## City of Ryde Submission

### Modification to Ivanhoe Estate Concept Masterplan SSD-8707-Mod-3

**Submission Date:** 31/05/2024  
**Council reference:** COR2024/78/1

01. NORTH EAST DEVELOPMENT LOTS (B1-B2)

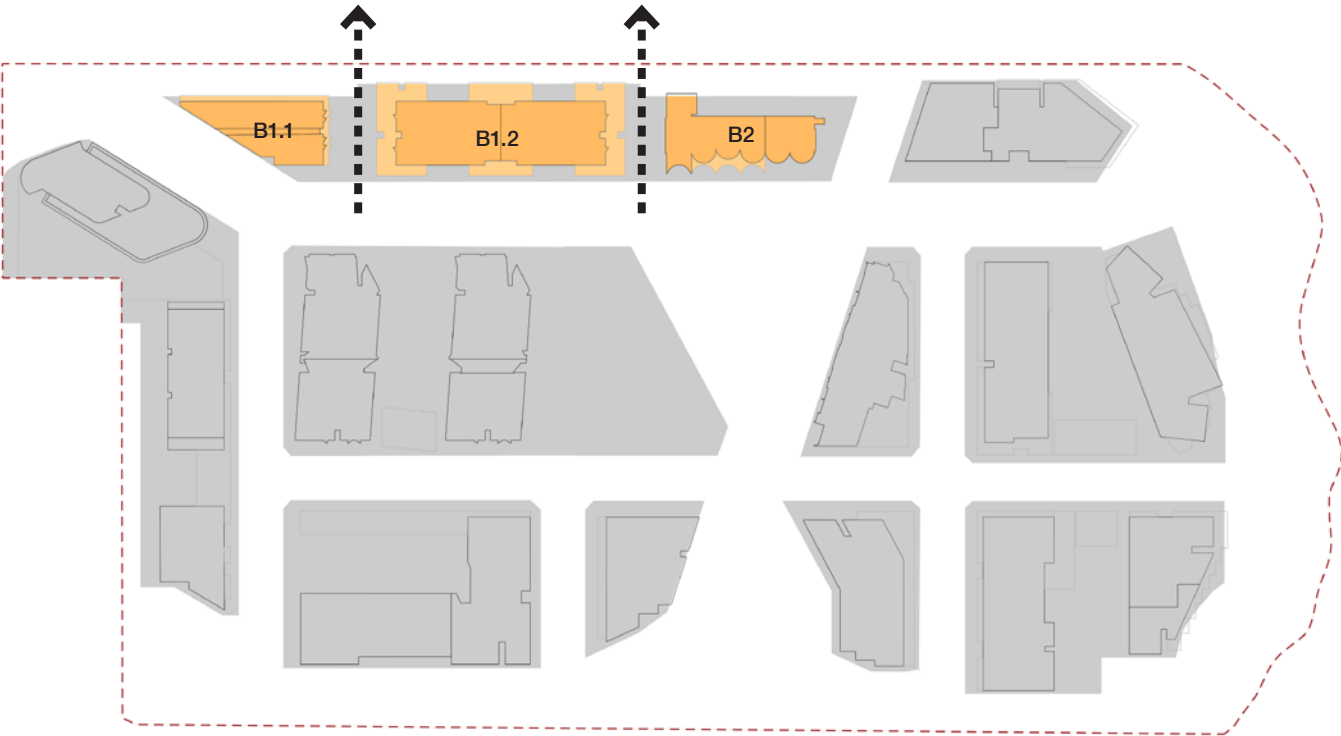
The rear setback for Block B2 is being reduced to 3m (for 1 storey component) and 6m (for the rest of the façade) along its northern boundary. The original approval required a clear 10m setback from the rear boundary. A reduction in this setback will also take away opportunities for tree planting along the boundary given that there is also a drainage easement/ pipe along that boundary. In addition, the reduced setback may impact on trees on the adjoining site (along Peach Tree Road). This has not been investigated and no details have been provided in the modification report.

Based on the above, Council is of the view that adequate consideration has not been given to the potential impact on the amenity of the adjoining residential sites.
